APPLICATION FOR PLAN REVIEW

NAME OF PROJECT: McConnell Waste Systems & Recycling

January 19, 2009

Application Number 08-50021260

08 500 21260
 SITE PLAN APPROVAL
 DISTRICT I
 #BEDROOMS 0 BED ROOMS 1 BATH
 12/05/08
 USE COMM STORAGE
 ZONING ADMINISTRATOR

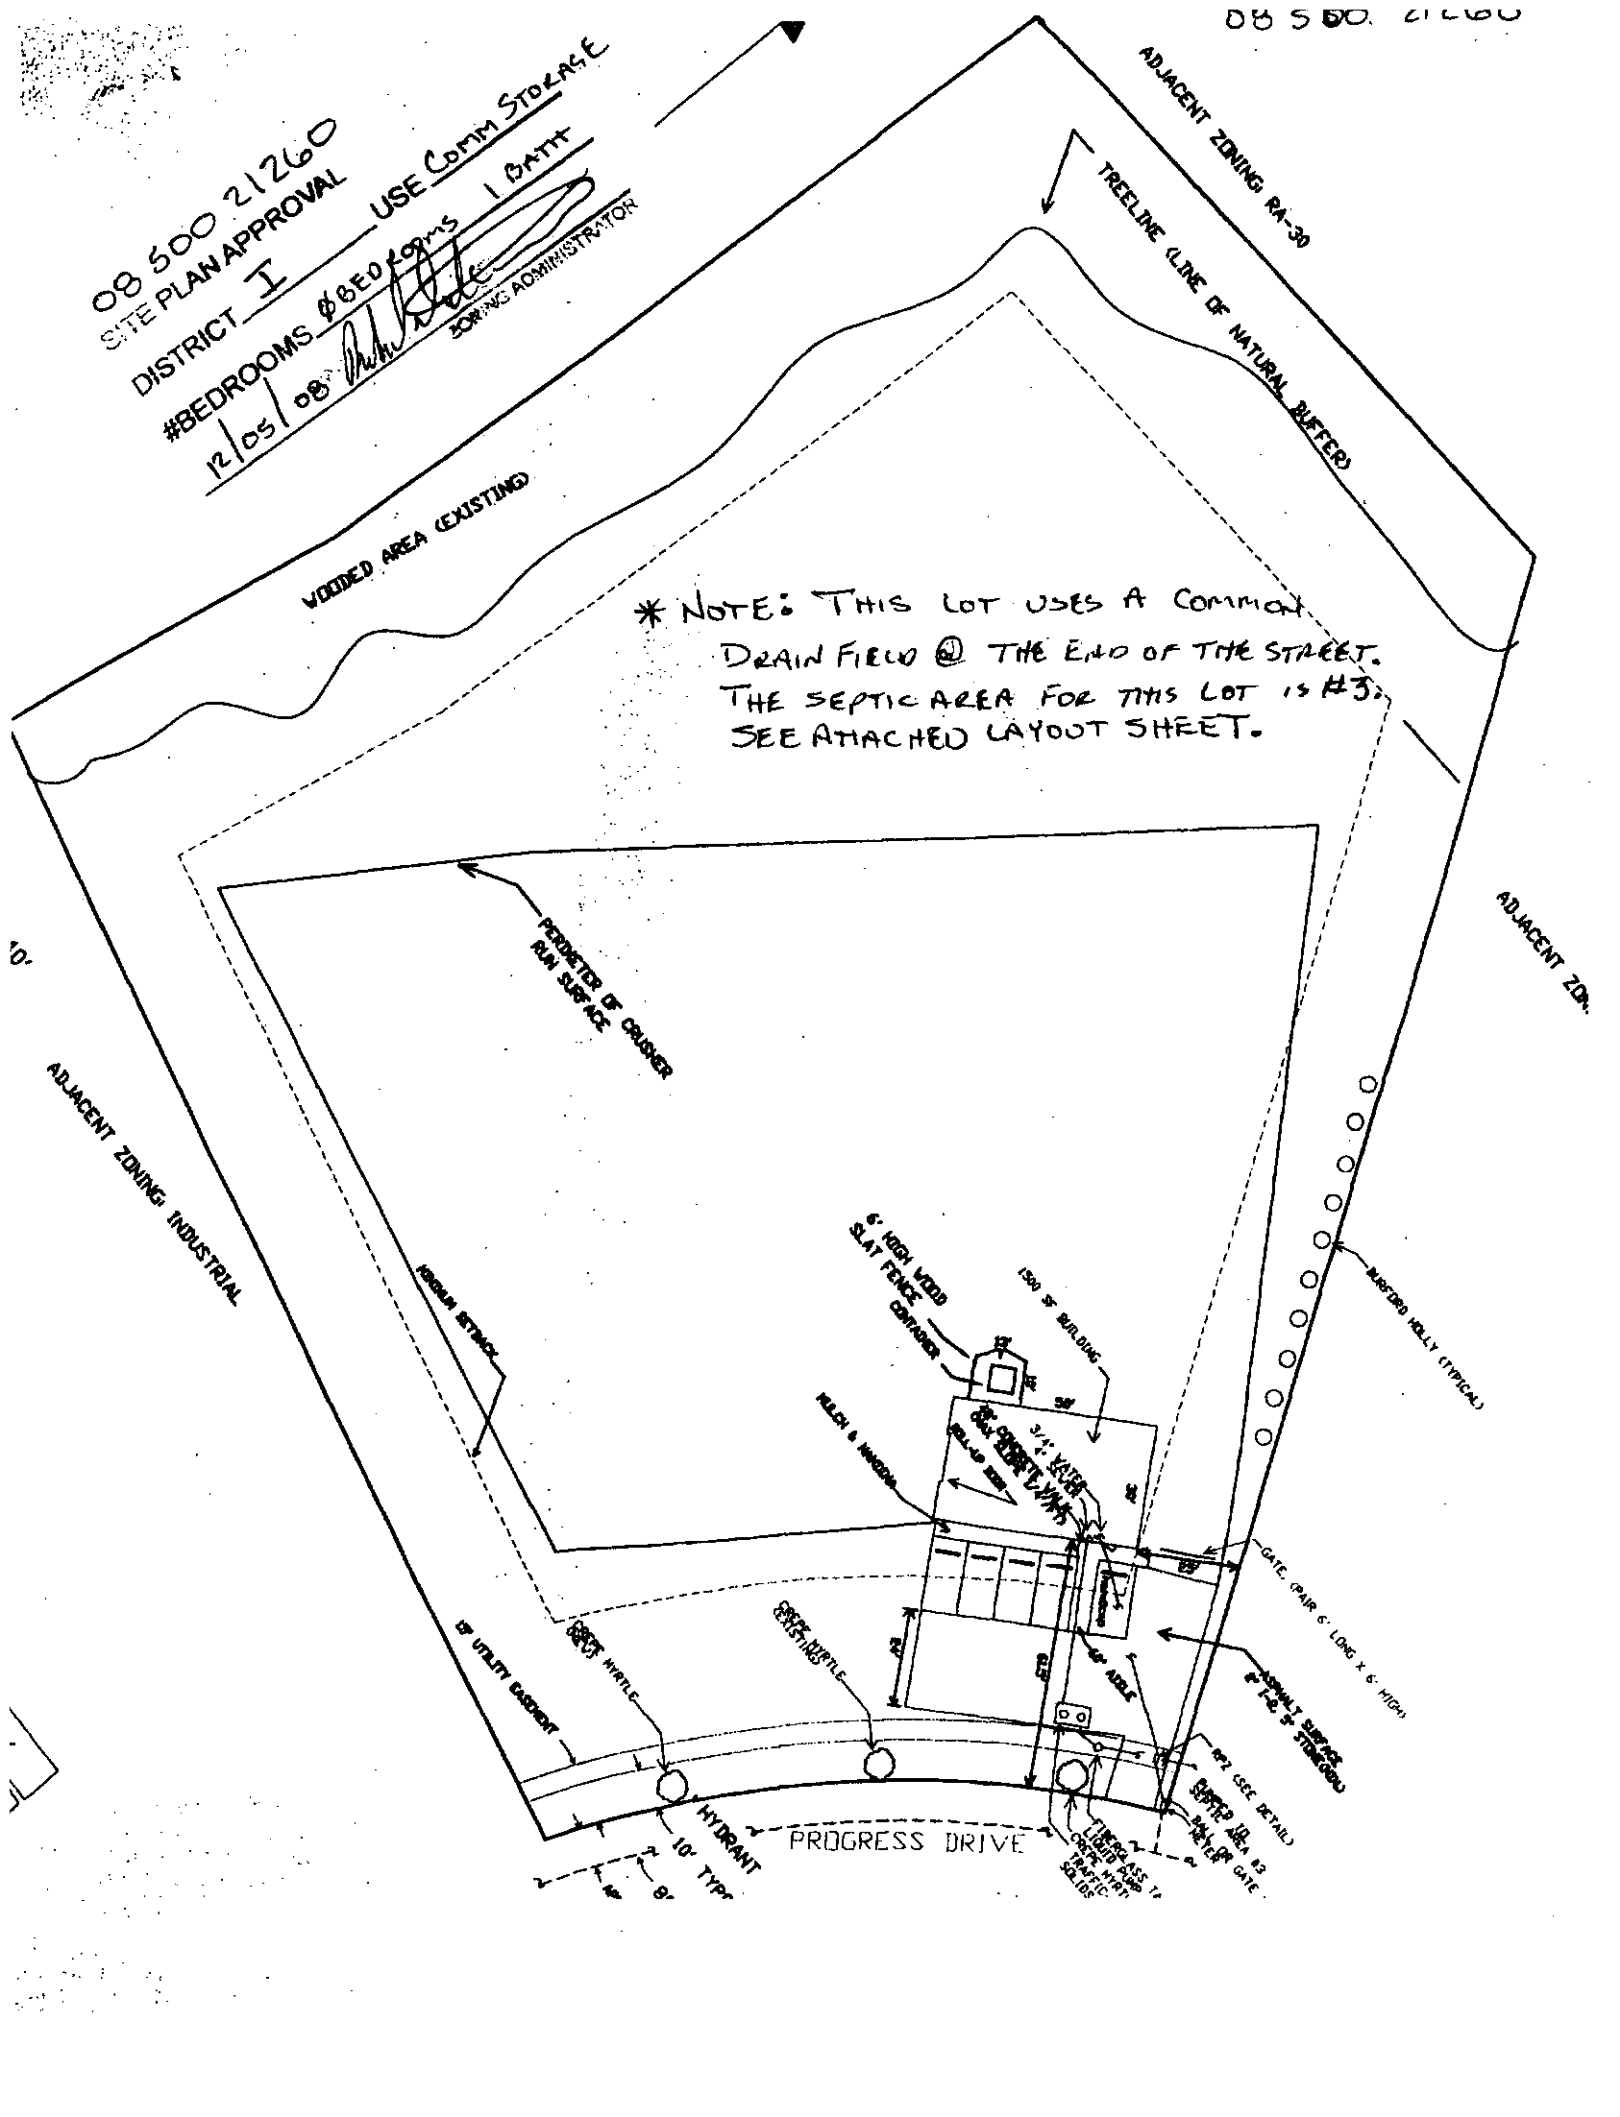
- **503.1.1 Fire Department Access**
 - The fire department access shall extend to within 150 feet of all portions of the facility.
 - The fire department access road shall be of an unobstructed width of not less than 20 feet and shall have an unobstructed vertical clearance of not less the 13 feet 6 inches.

- **508.5.1 Fire Hydrants**
 - In accordance with the Fire Code, a hydrant must be within 400' of a new occupancy classification in which your building would be categorized in.
